ABNORMALS COMMENTARY

**PROPOSED RESIDENTIAL DEVELOPMENT
KERESFORTH ROAD, DODWORTH,
BARNSELY**

CP VIABILITY

OCTOBER 2025

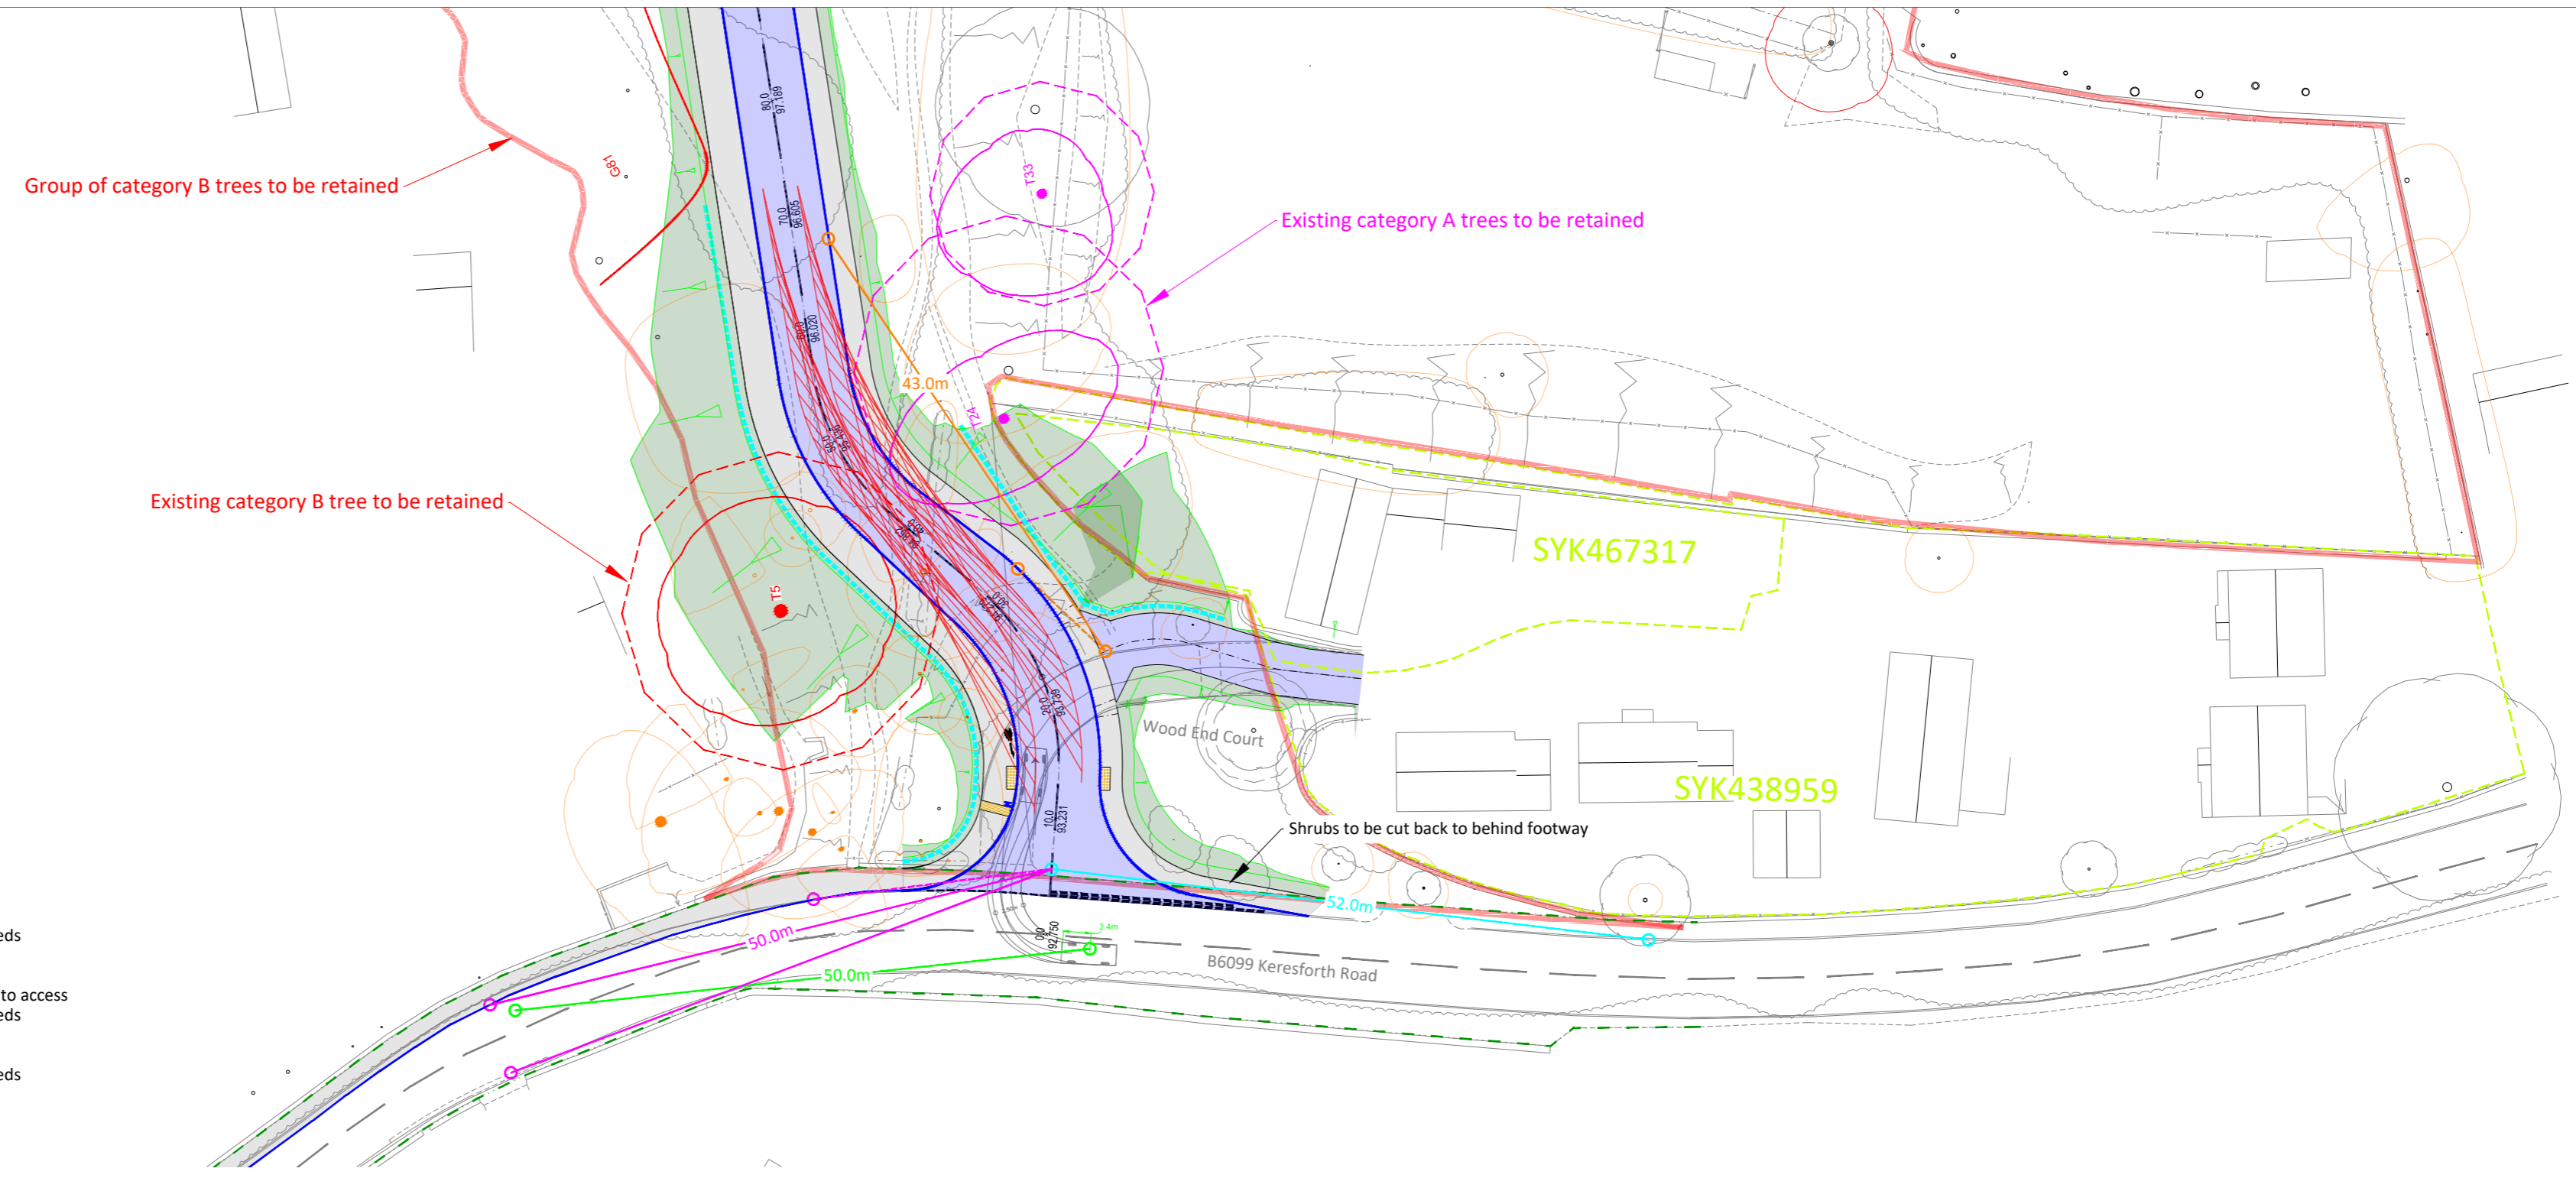
We assume this cost includes s.278 works and other works outside the site boundary. The figure of £1,201,821.10 indicates an extension scope and would require further information to assess this element as an abnormal cost.

Client KEEPMOAT				
Project KERESFORTH ROAD, DODWORTH				
Detail PRELIMINARY FEASIBILITY PLAN - SOUTH				
Own	Chkd	Date	Scale	Dwg No.
HH		OCT-20	1:500@A0	E207774/001-02C

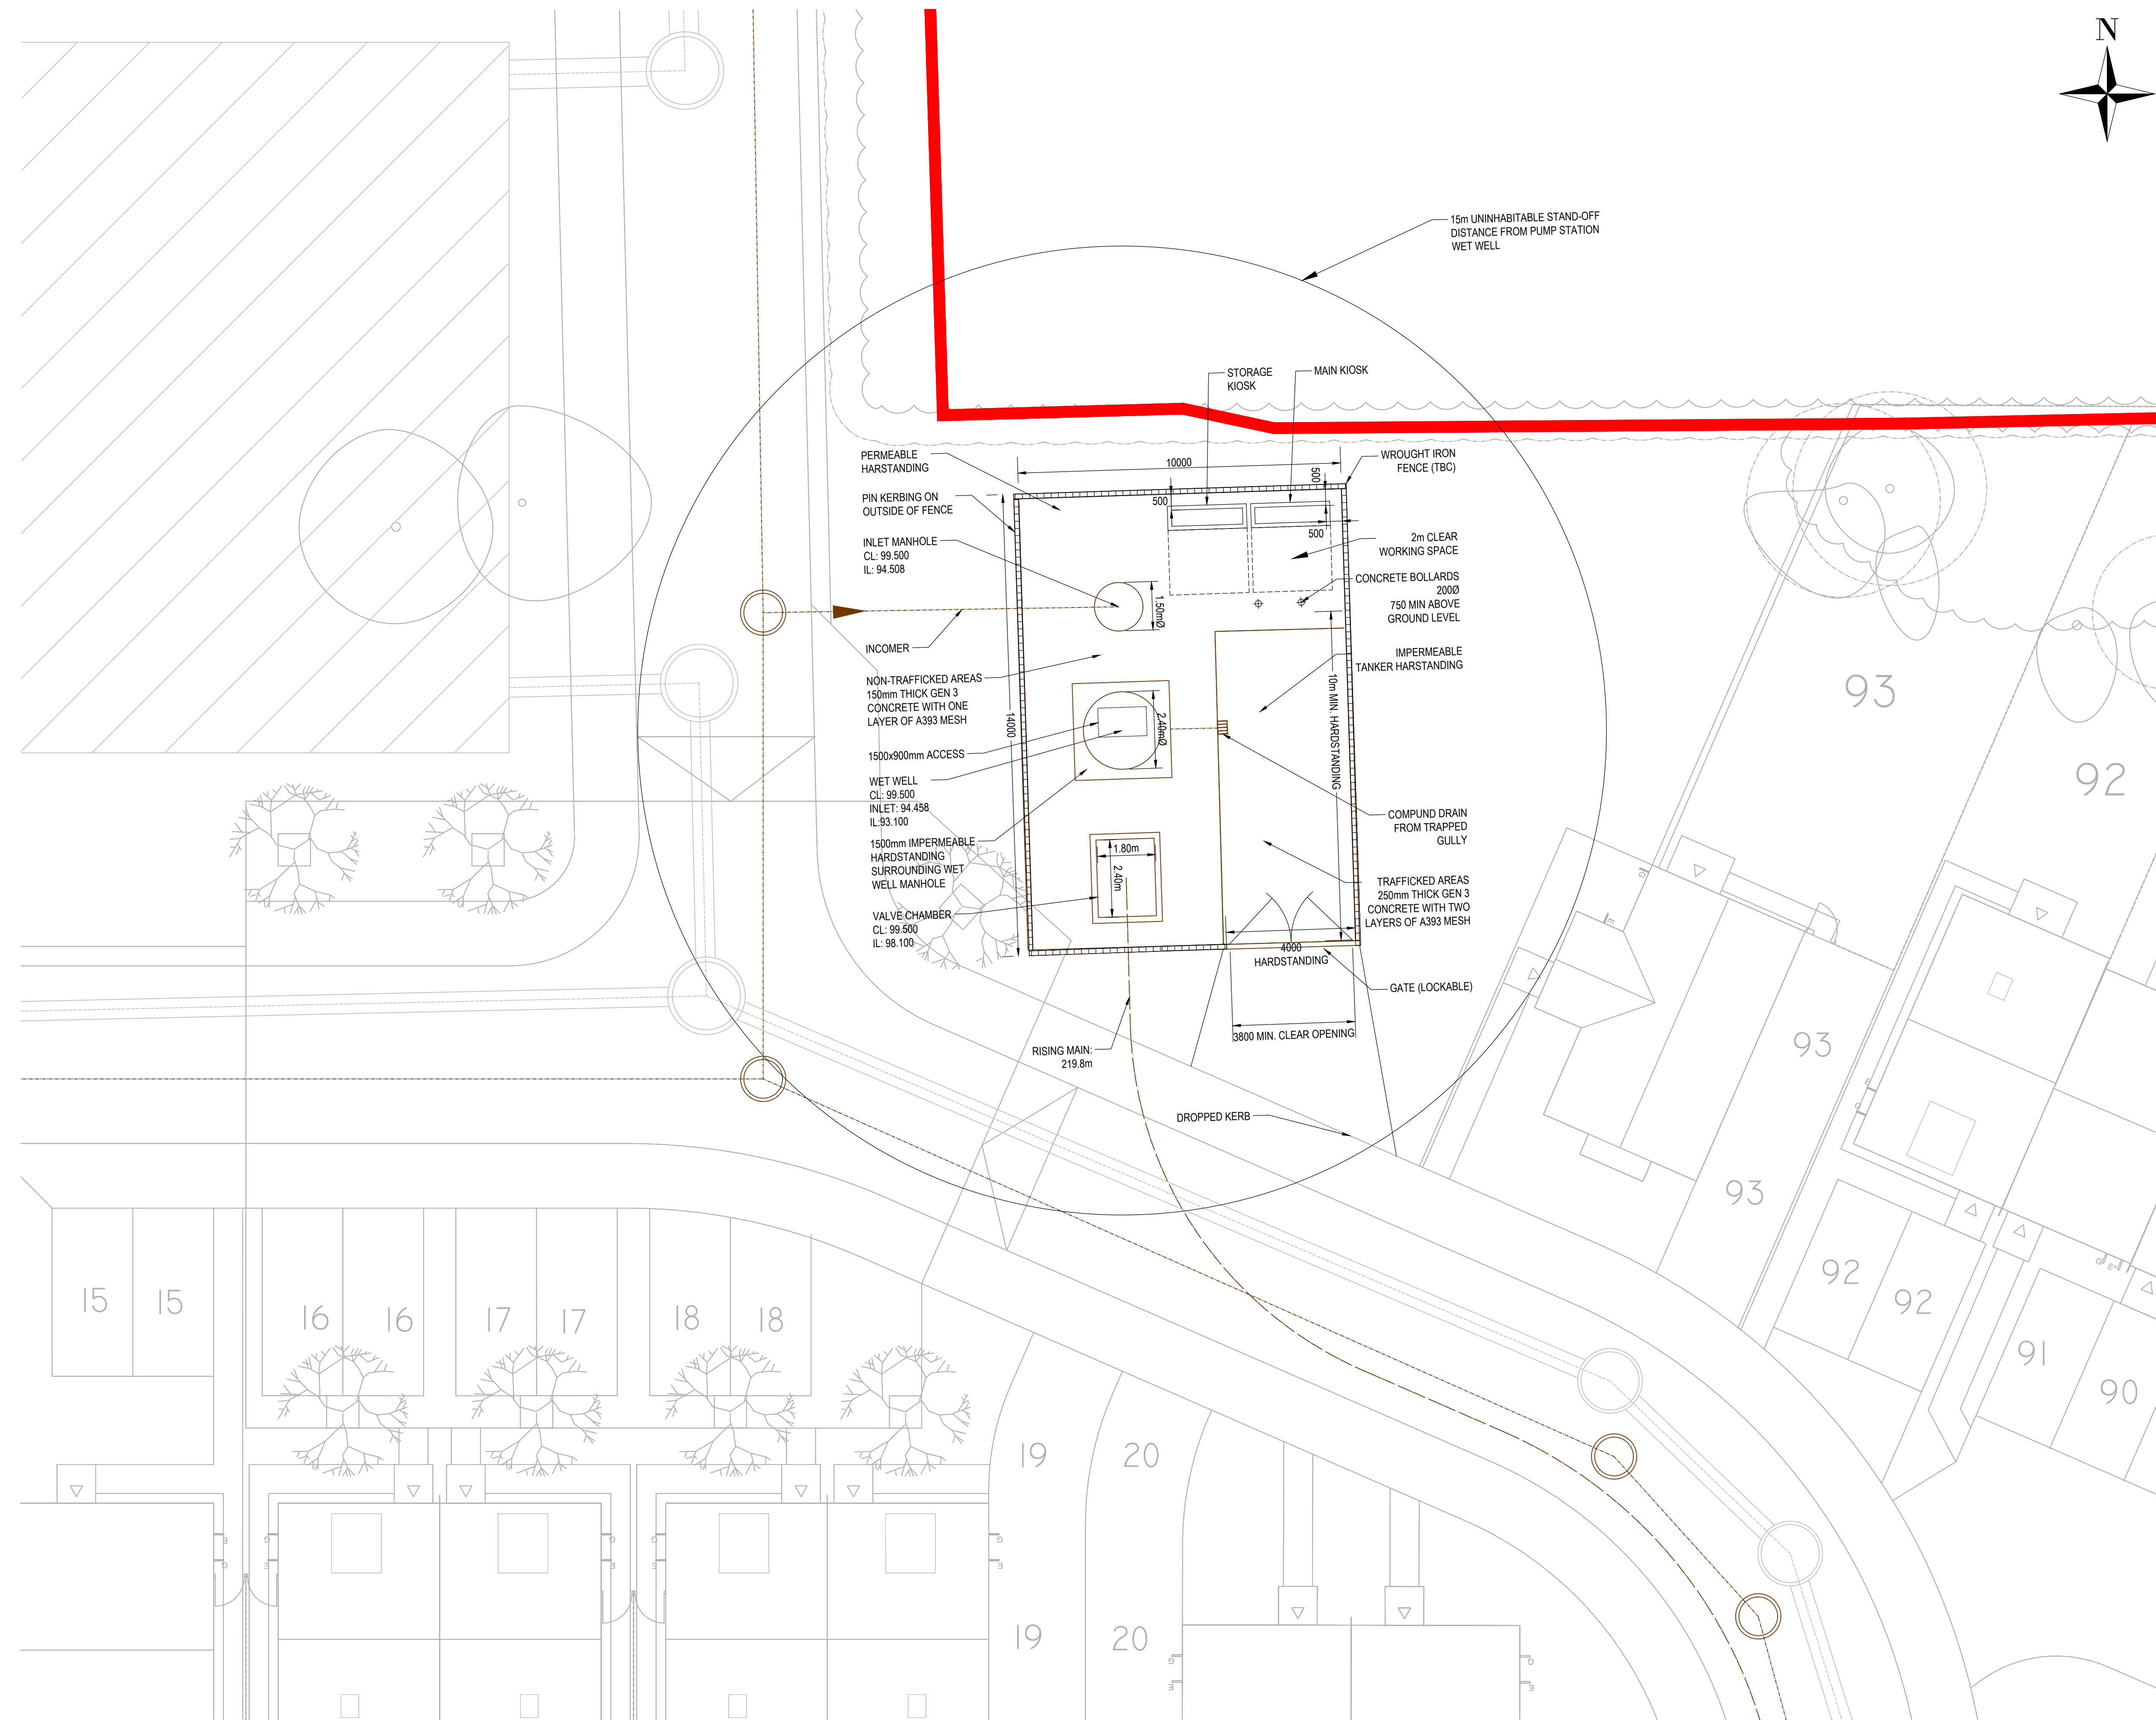
As per our comment for Item 4.1, it is unclear where driven piles might be required. We note that there is considerable cut & fill, and we could speculate that piling might be required in areas of fill, we are unable to verify this as an abnormal without further detailed build-up and provision of supporting reports.

Based upon the information available, we calculate the length of retaining walls protecting the east-west culvert in the centre of the site as 68m, and the retaining walls either side of the site access off Keresforth Road a total of 31m. We note that each of the retaining walls include extensive earthworks, foundations, and pedestrian barriers/handrails.

However, the superseded drawings also show a proposed retaining wall to the rear of the north-south row of houses near the centre of the site, and we measure this as 160m but with the caveat that the design may have altered since we do not have sight of updated drawings.

HV & LV Diversions
Keresforth Road
Dodworth

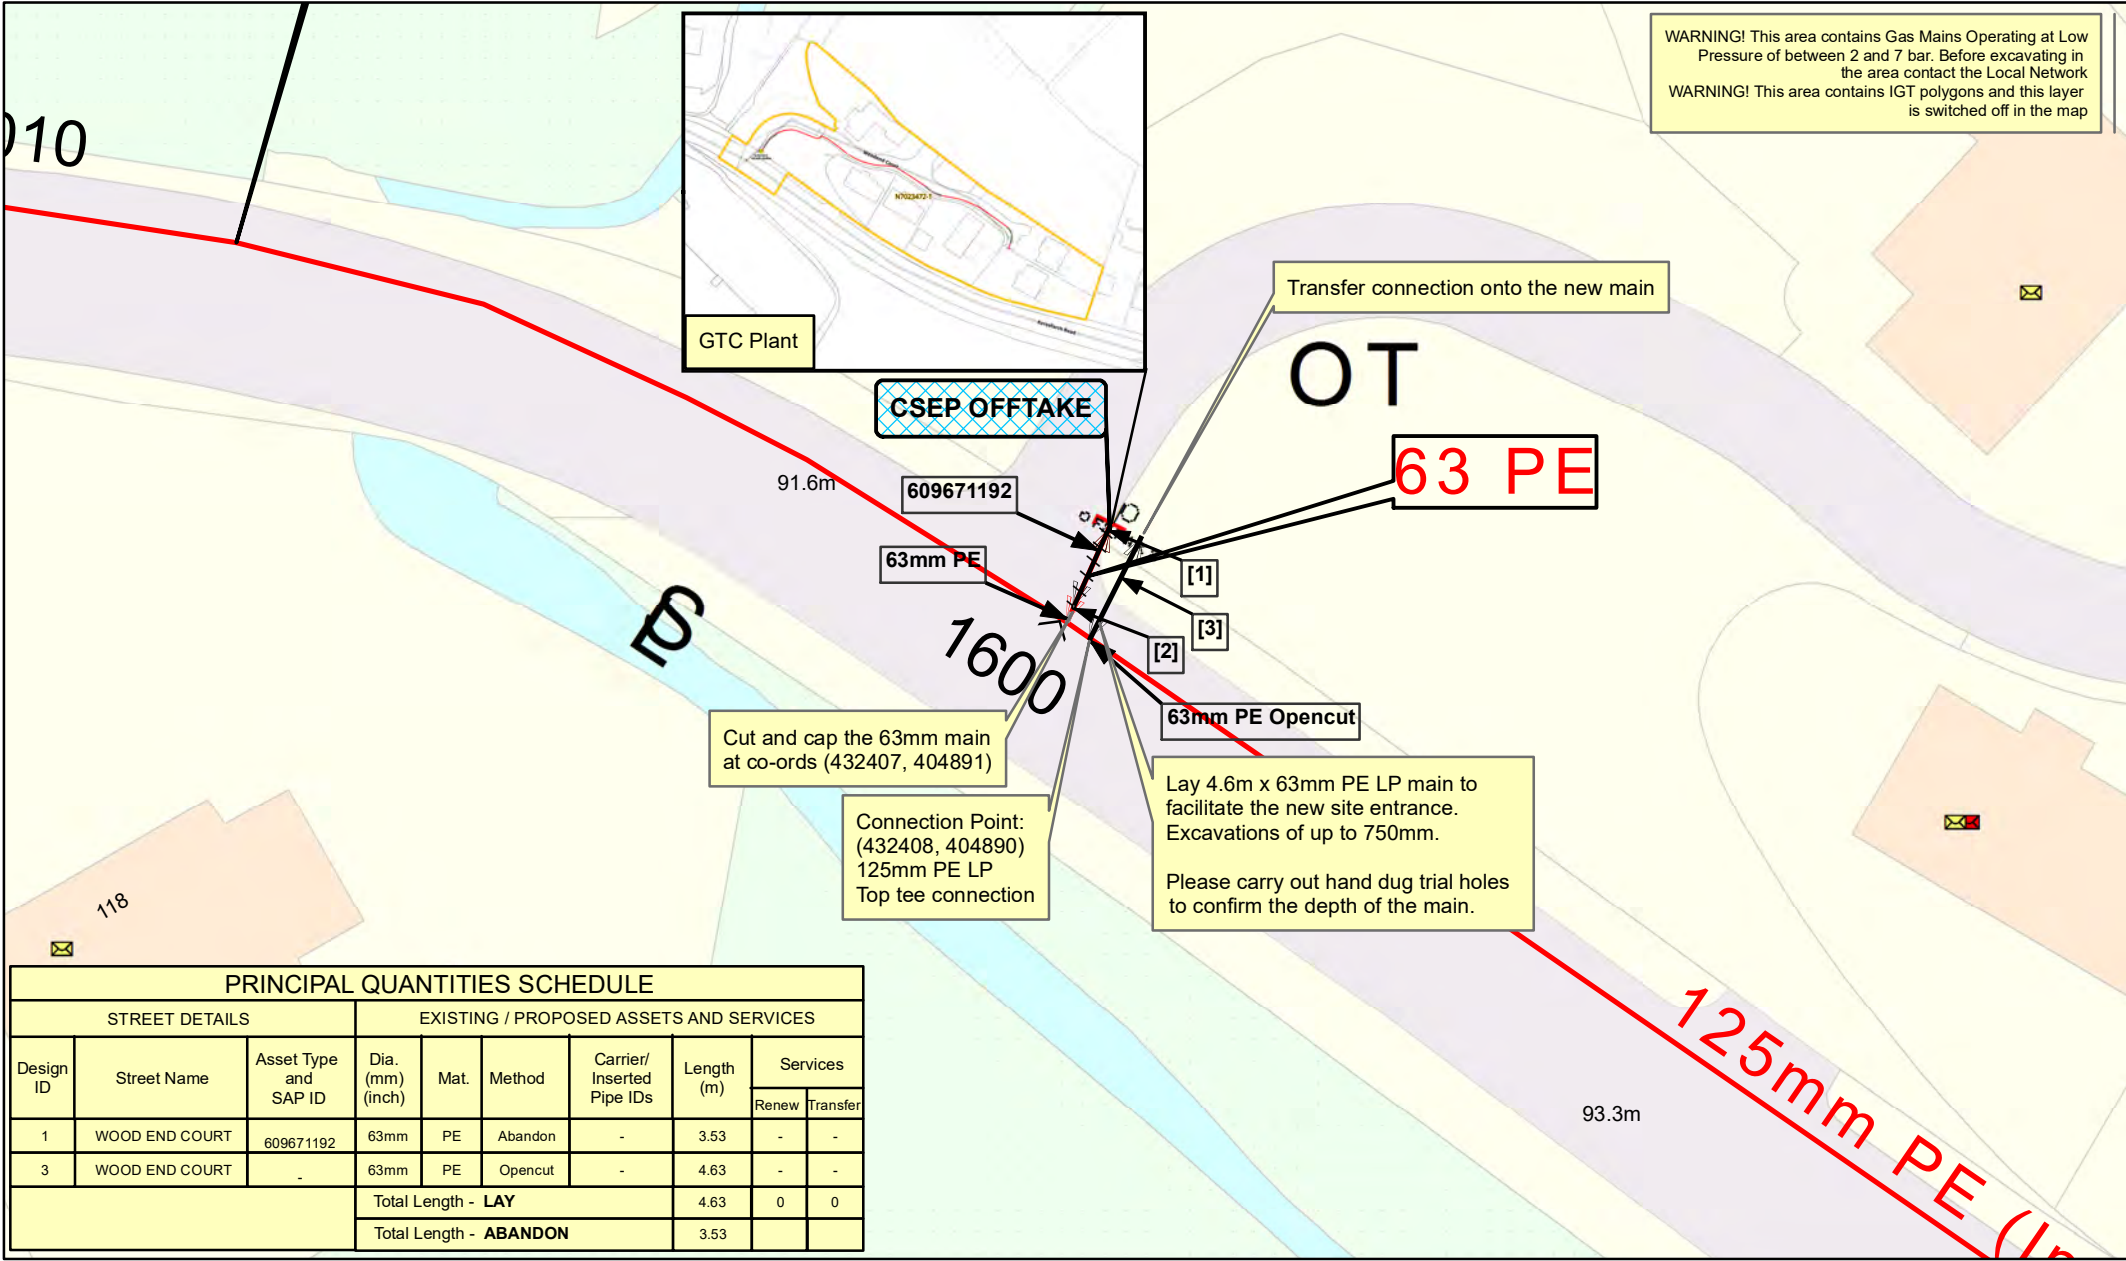
The site is a greenfield site without any known statutory services. We are unable to verify this element as an abnormal cost.
